WEST SUSSEX COUNTY COUNCIL CONSULTATION

TO:	Arun District Council FAO: Andrew Wood
FROM:	Highways, WSCC: Tim Townsend
DATE:	11 th February 2019
LOCATION:	Former Windroos Nursery, Worthing Road, Littlehampton, BN17 6LY
SUBJECT:	LU/25/19/DOC Approval of details reserved by condition imposed on planning reference LU/229/10 relating to Condition 11 - Vehicle Swept Path, Adoption and CMS.
DATE OF SITE VISIT:	
RECOMMENDATION:	☒ Advice ☐ Objection ☒ Modification ☐ No Objection ☒ More Information ☐ Refusal
S106 CONTRIBUTION TOTAL:	£(N/A for purposes of this application)

This is the County Highways Authority (CHA) response to the above planning application for approval of details reserved by condition imposed on planning reference LU/229/10 relating to Condition 11 - Vehicle Swept Path, Adoption and Construction Management Statement (CMS).

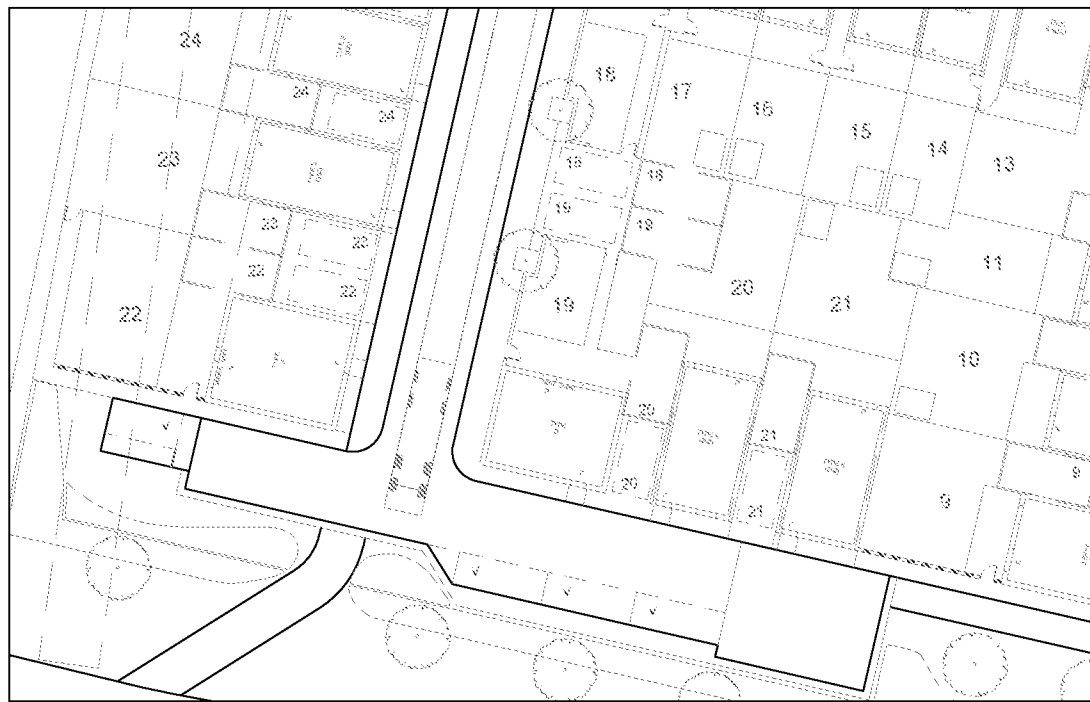
Vehicle swept-path (VSP) – While VSP diagrams have been submitted showing the tracking of both refuse and fire appliance vehicles – both within the layout and through a junction arrangement proposed when the application was originally submitted - the VSP appears on a different version of the layout from that shown on the "S38 General Arrangement" (Drawing No. 063.5001.105 Rev. 'A'). As such, the applicant should confirm the final layout and confirm that the tracking is on the correct drawing. The tracking should also be shown on a drawing showing the proposed alterations to the A259, as proposed by WSCC. Copies of the latter can be obtained on request from the CHA.

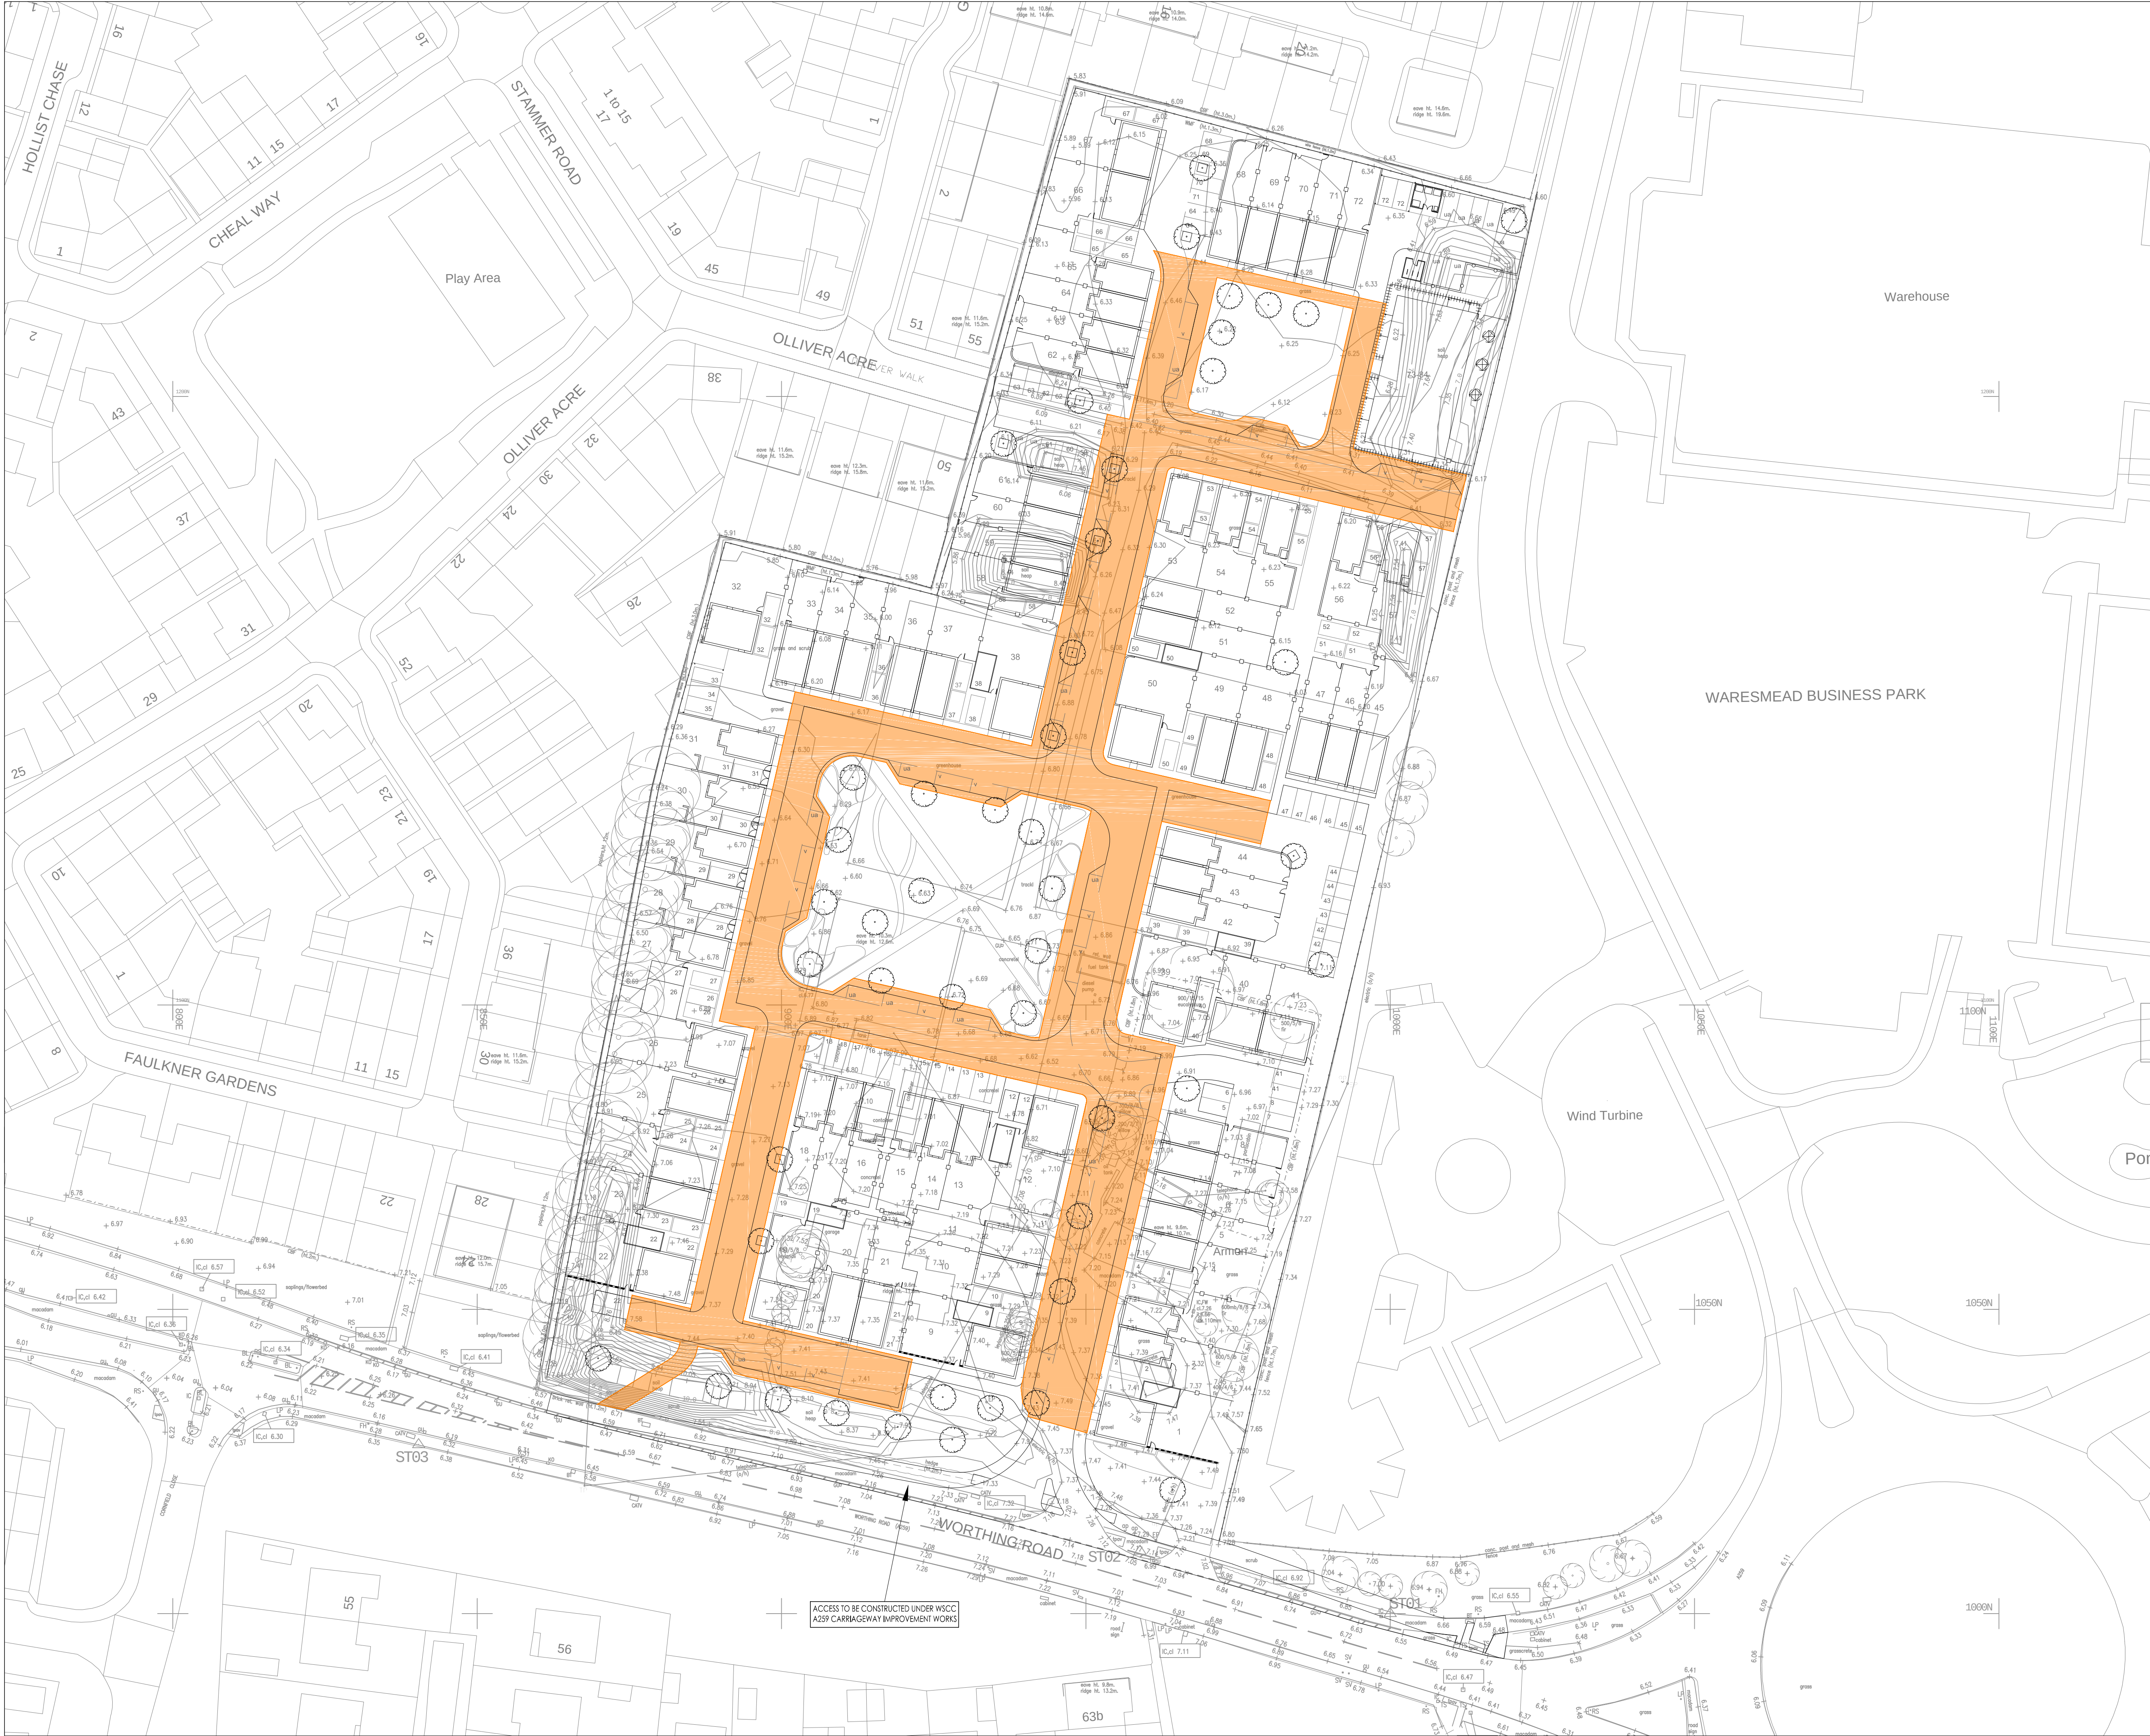
Adoption – Like the comments made above, the applicant should confirm what plan is the correct one showing extent of proposed road adoption. When received, the CHA will provide further comments. Likewise, comments about the materials proposed will also be made once the correct plan is provided. Street lighting specification does not appear to be available at the time of writing. This too should be submitted. Also see comments under 'other matters' found below.
